Letter No. B2/21471/93

Sub: MDA - APU - Construction of
Residential/~~Commercial Building~~ **XXXXXX XXXXXXXXXXXXXXXX Group Housing**
at S.No. **77/9, 78/4, 83/1 XXXXXXXX 83/2, 84/1** **Development**
84/2 & 85/1 in
Remittance of D.C., S.C., S.D., **Noombal**
XXXXXX **Village.**
O.S.R., S.D. for upflow filter -

The Planning Permission Application received in the reference cited for the ~~additional~~ construction of Residential ~~Plots/Commercial Building~~ at the above site under reference was examined and considered to process further ~~subject to Metro Water Clearance and~~ subject to the following conditions stipulated by virtue of provisions available under DCR 2(b)ii:-

ROOF PLAN

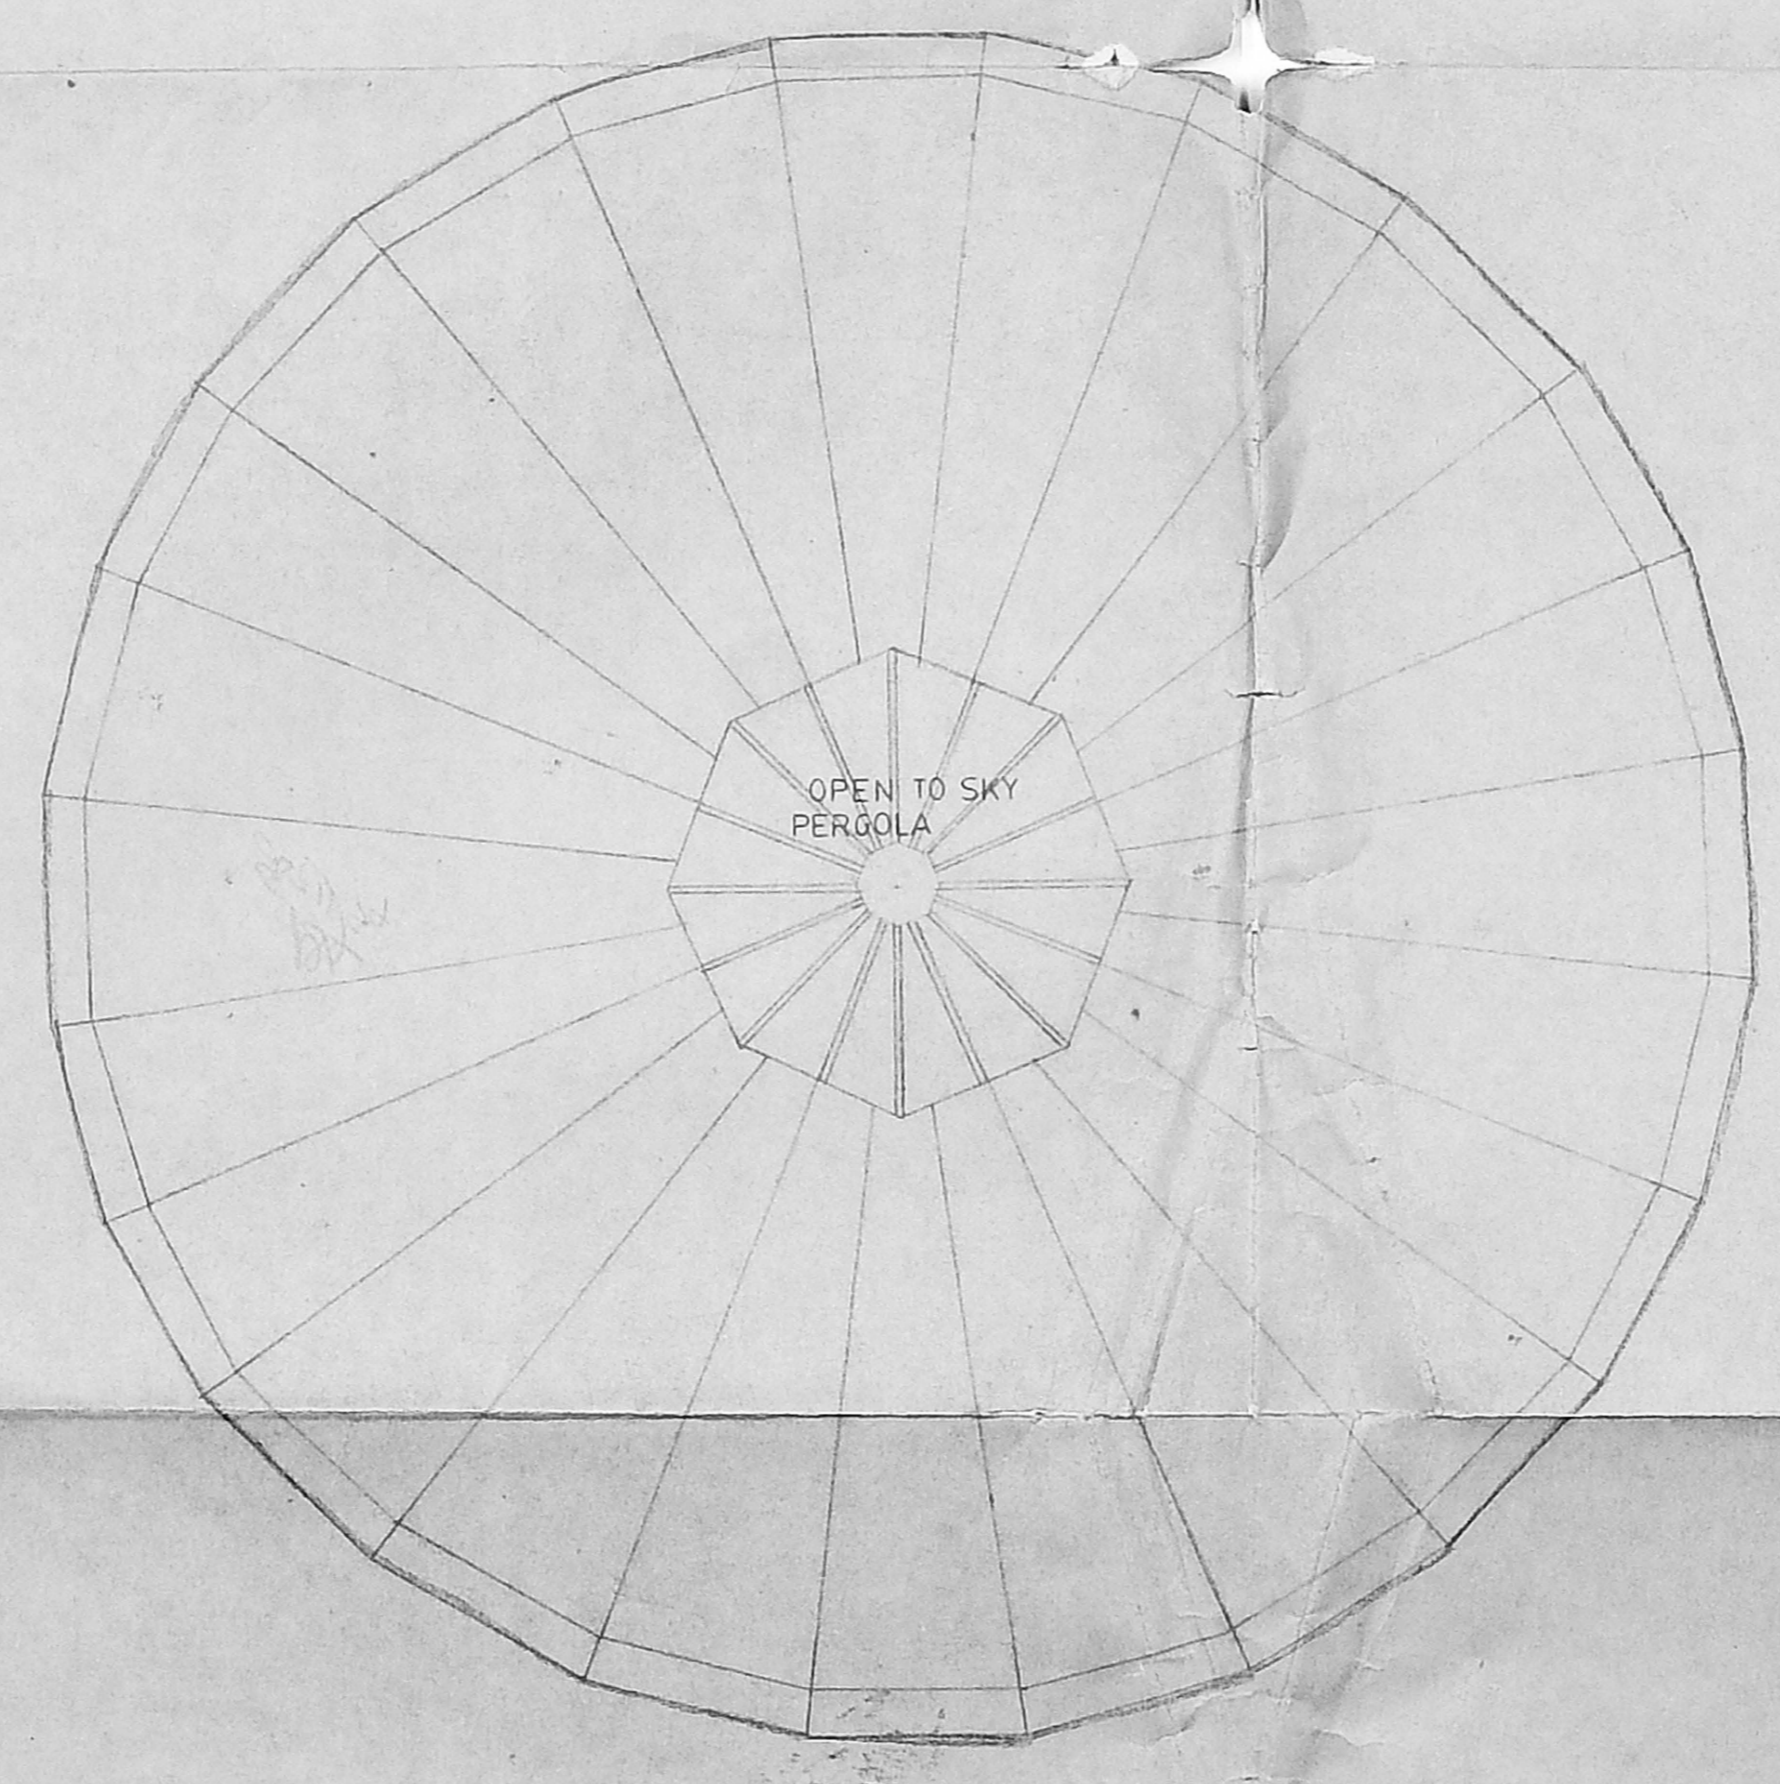
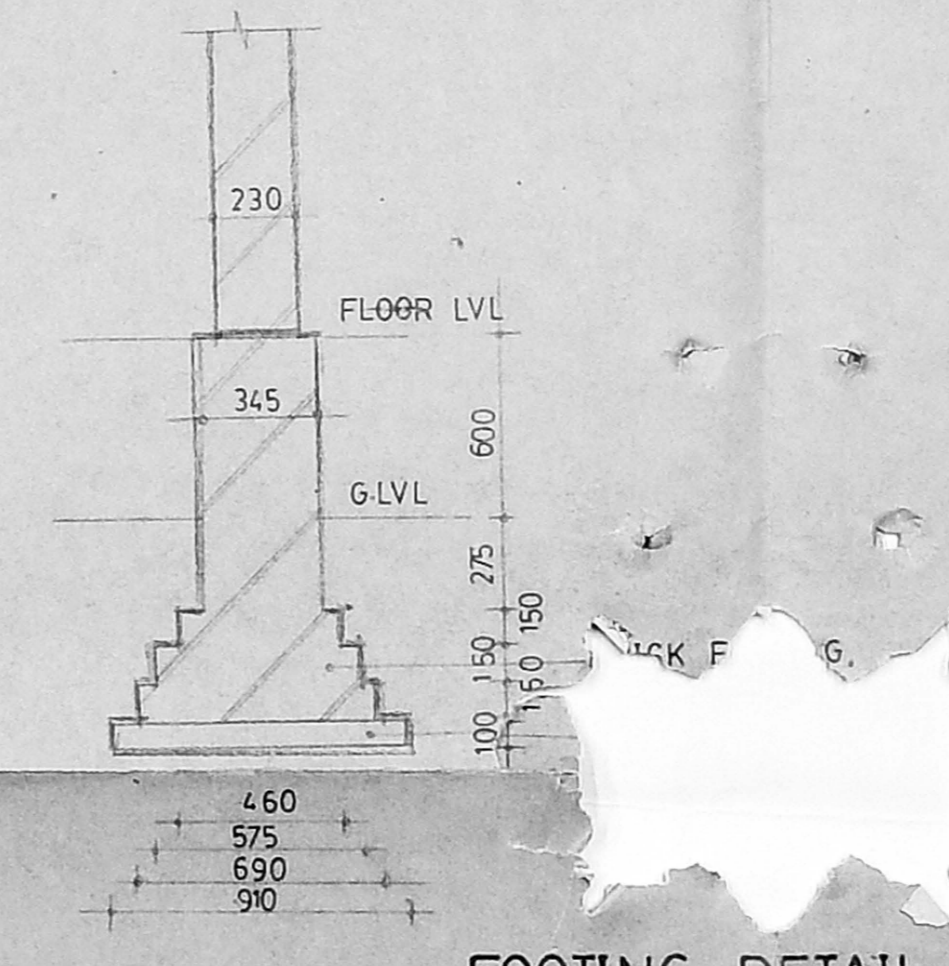
- c) Furnish the information and letter of undertaking as required under 2(a) and 2(b) above.
- d) Give an undertaking in Rs. 10/- stamp paper attested by the Notary Public (A copy of the Format is enclosed herewith).
- e) A copy of the format enclosed for display of particulars for ~~SS~~ Special Buildings and the display with details at the site is compulsory.
- f) For the payments received after one month, interest shall be collected at the rate of 12% per annum (i.e. 1% per month) for the every completed month from the date of issue of this advice.
- g) You are requested to furnish revised plans providing a primary school and showing its location and detailed plans for the same.4.
